Our ref: HA/2020/122528/01-L01
Your ref: LU/163/20/PL

DEMOLITION OF EXISTING CONSERVATORY, SINGLE STOREY FRONT & REAR EXTENSIONS & CHANGE OF USE FROM HMO (SUI GENERIS) TO 5 NO. FLATS (4 NET) (C3 DWELLING HOUSE). THIS APPLICATION AFFECTS THE CHARACTER & APPEARANCE OF THE LITTLEHAMPTON SEAFRONT CONSERVATION AREA & MAY AFFECT THE SETTING OF A LISTED BUILDING. THIS APPLICATION IS NOT CIL LIABLE AS FLATS IN ZONE 4 (ZERO RATED).

6 SELBORNE PLACE SELBORNE ROAD LITTLEHAMPTON BN17 5NH

Environment Agency Position

Proposed Second Floor Plan 1:50

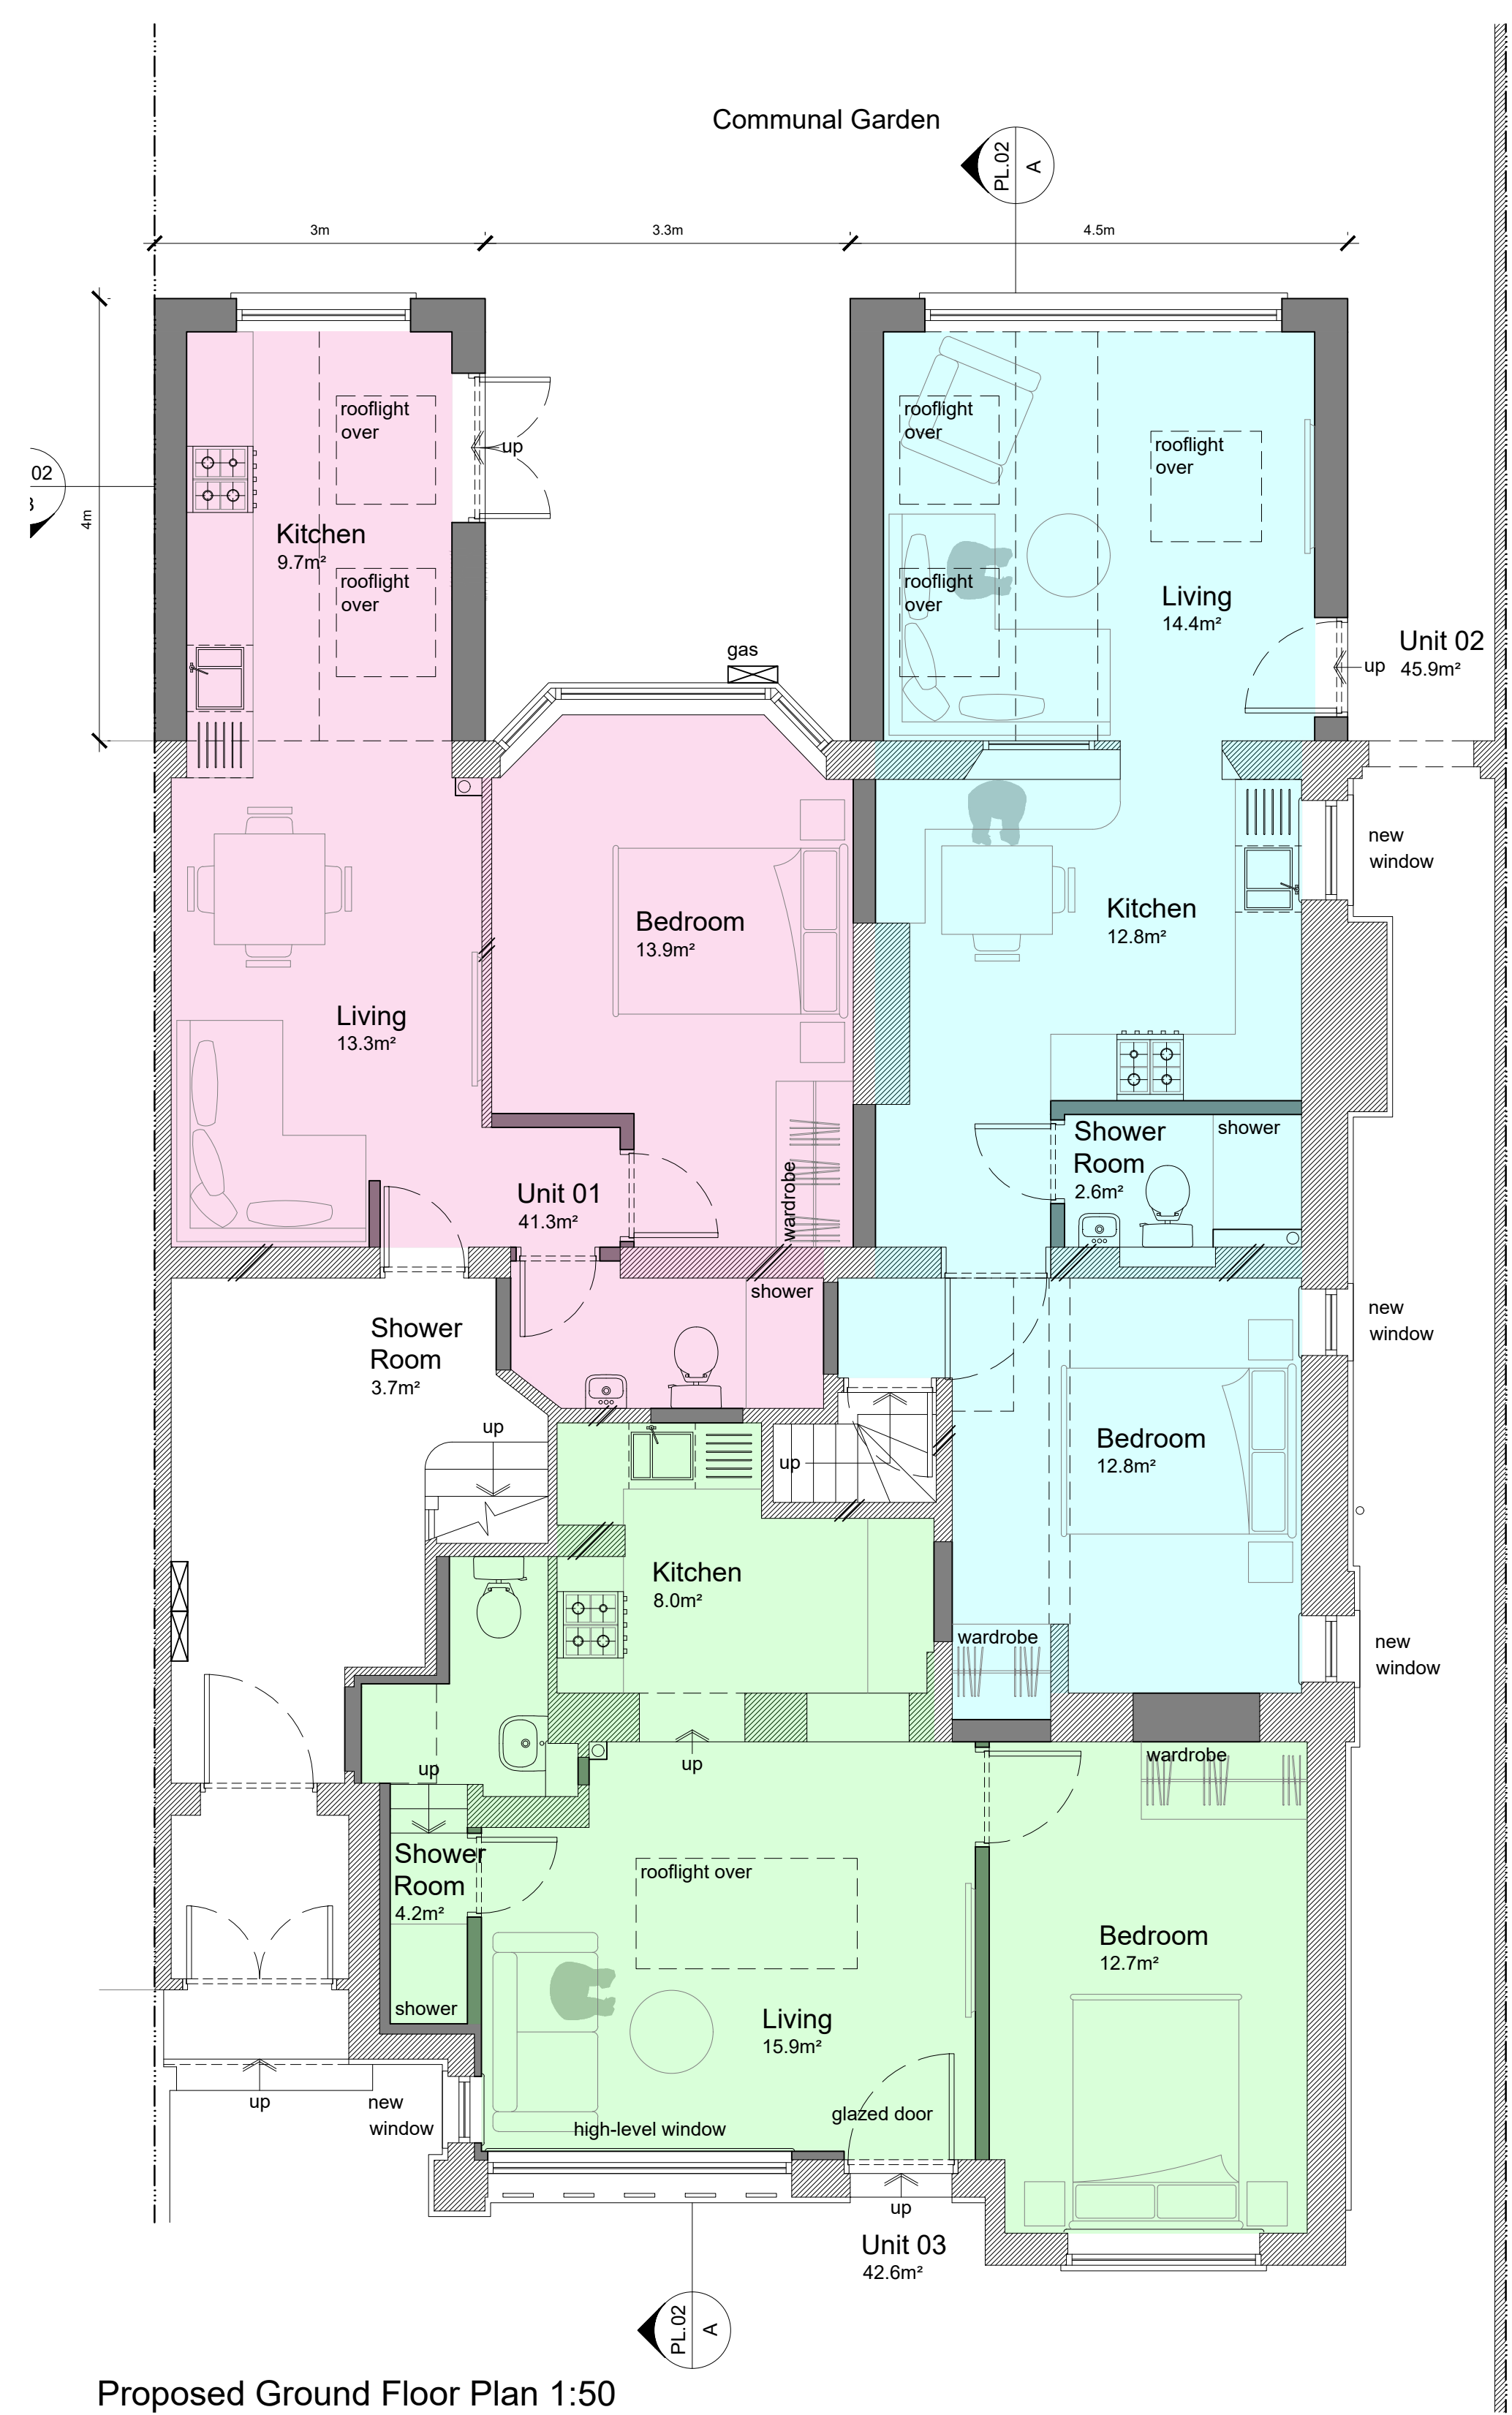
- consider how residents in the proposed ground floor bedrooms will be kept safe from the identified flood hazards in the Flood Risk Assessment.
- consider the requirement for flood emergency planning including flood warning and evacuation of people for a range of flooding events up to and including the extreme event

example will flood resilience products be installed to prevent flood water ingress to the ground floor where residents will be sleeping, will there be warning and evacuation procedures.

To overcome our objection, the applicant should submit a revised FRA which addresses the points highlighted above. The original FRA has identified the flooding risks, however further information on mitigation actions for those risks will need to be provided, for
